BARGHAUSEN

February 3, 2023

RE: Responses to Comments
Dutch Bros. Coffee (NM-0203)
210 98th Street, N.W., Albuquerque, New Mexico 87121
Our Job No. 22187

Job Number  
**22187**  
Sheet  
**C2.0**  
2019 DB  
Franchising USA, LLC

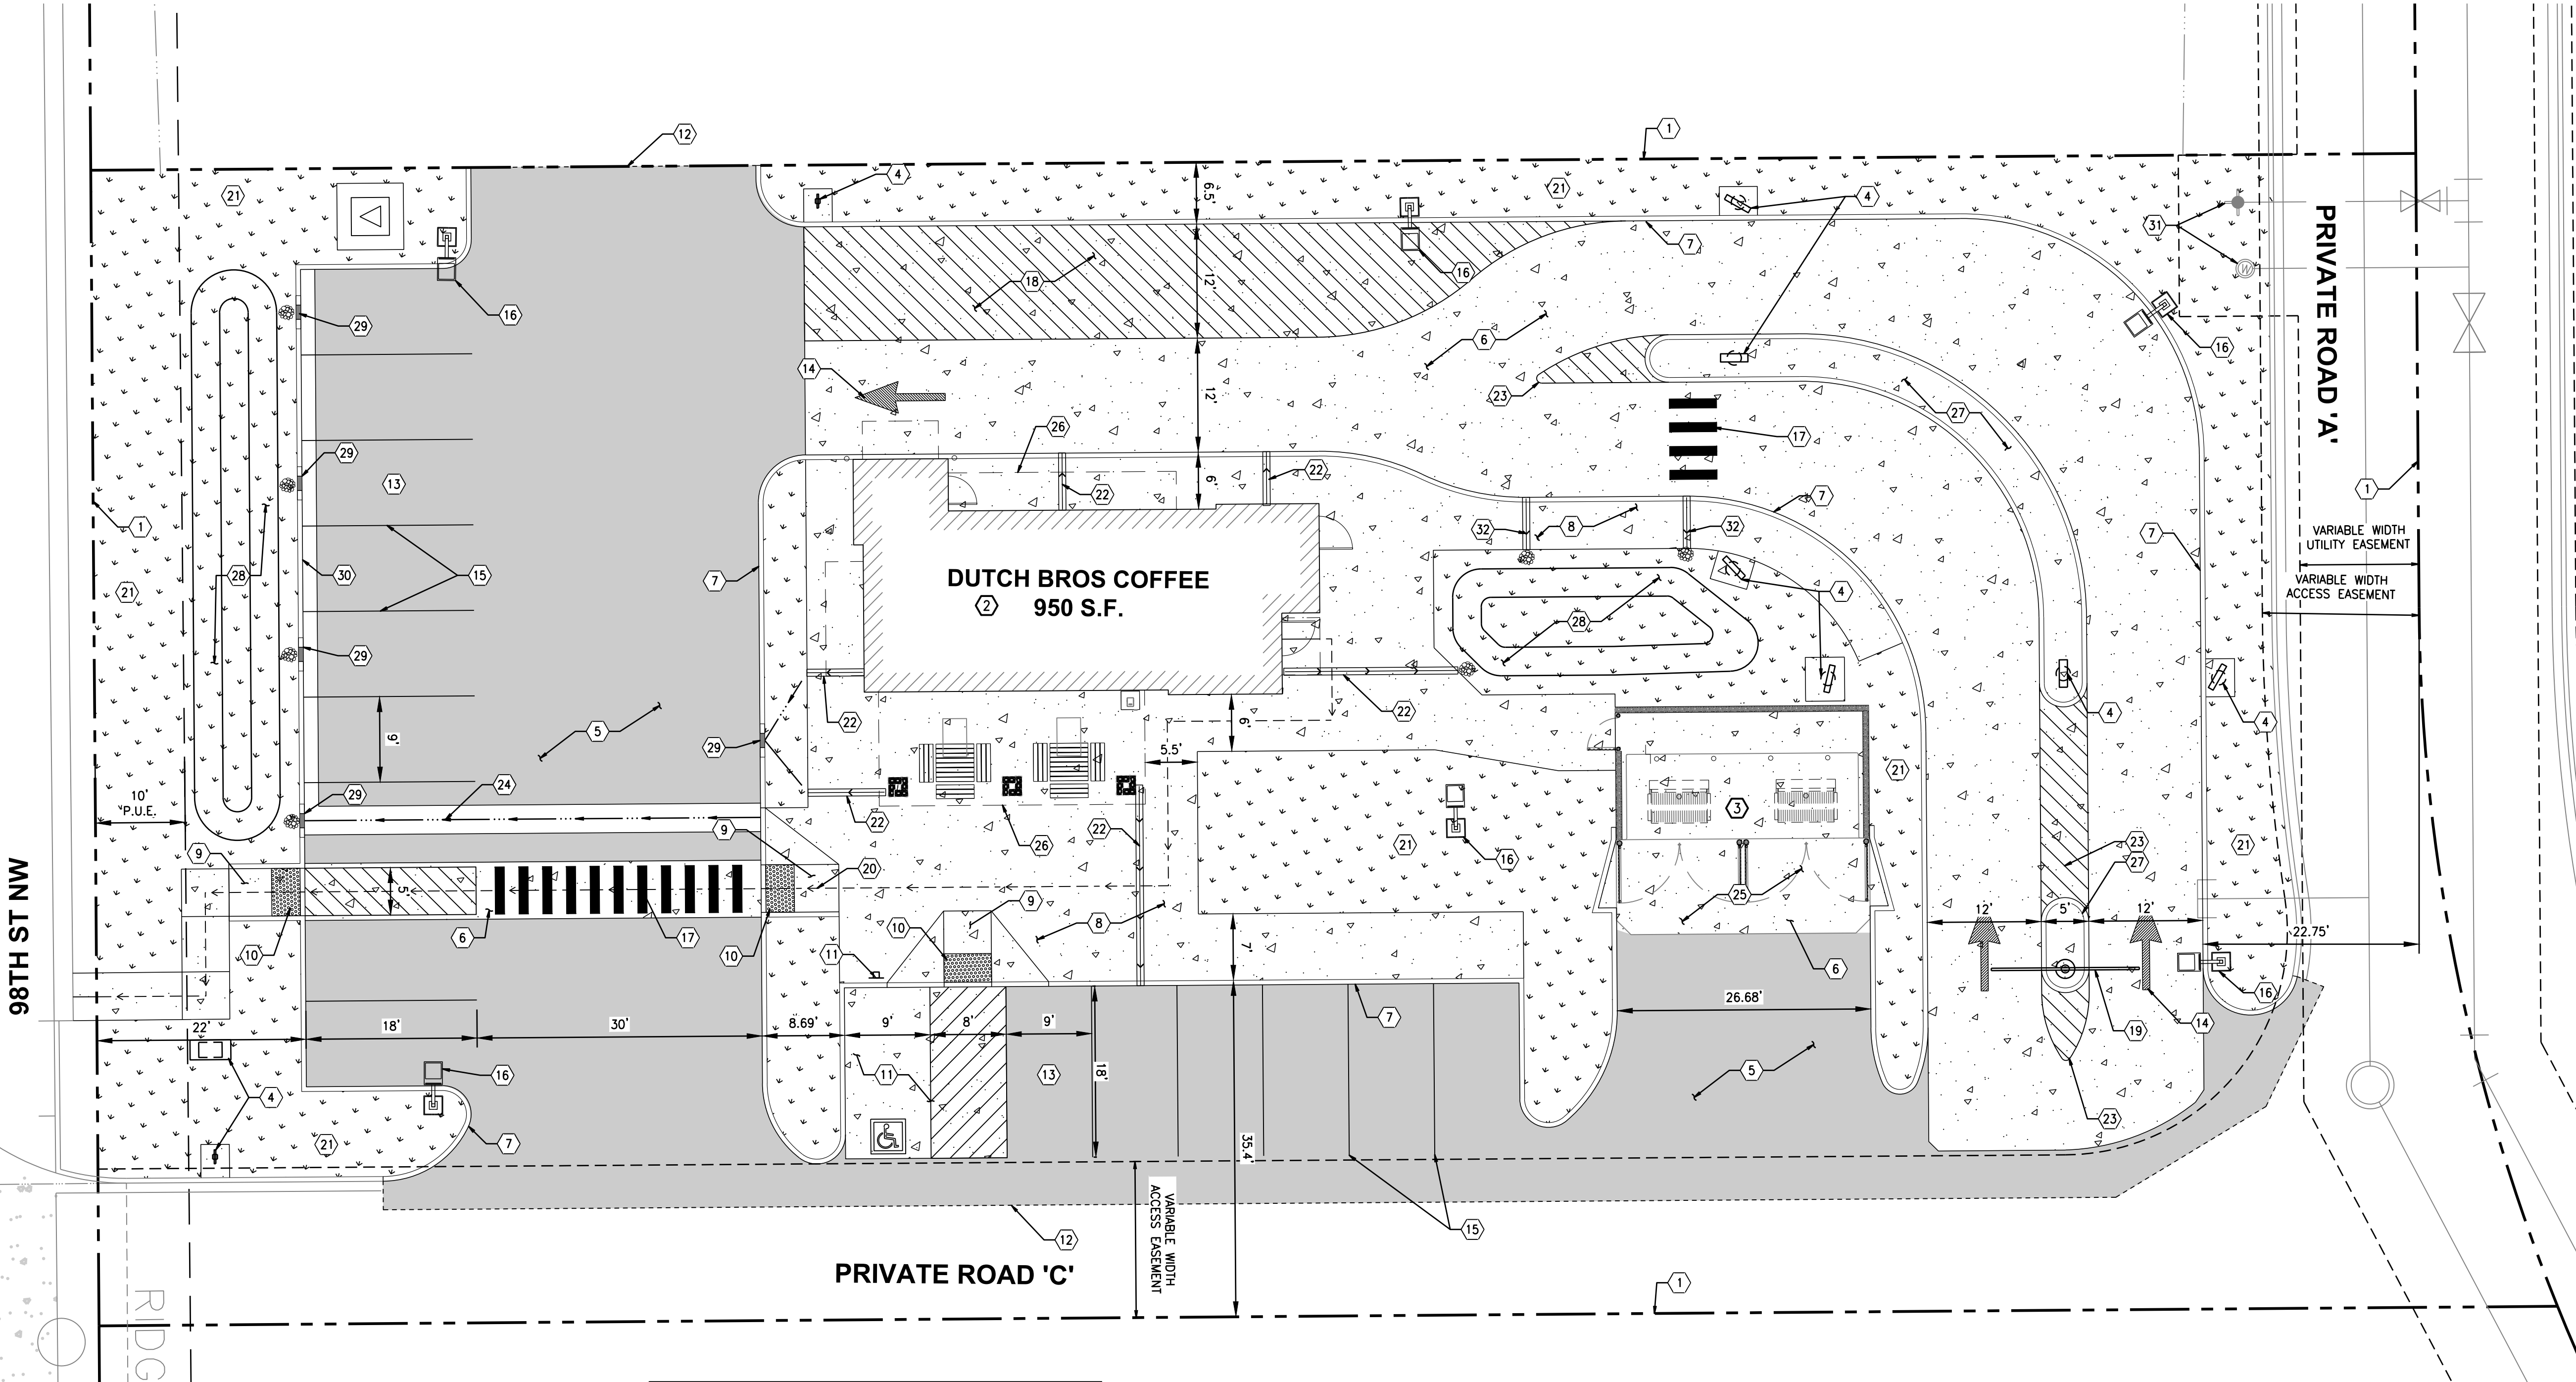
1. *Add a Do Not Enter sign (R5-1) to be placed at the drive through exit lane. Include the sign face details in the plans.*

Response: A "Do Not Enter" (R5-1) sign has been placed at the drive through exit. The sign face detail has been placed on C2.0.
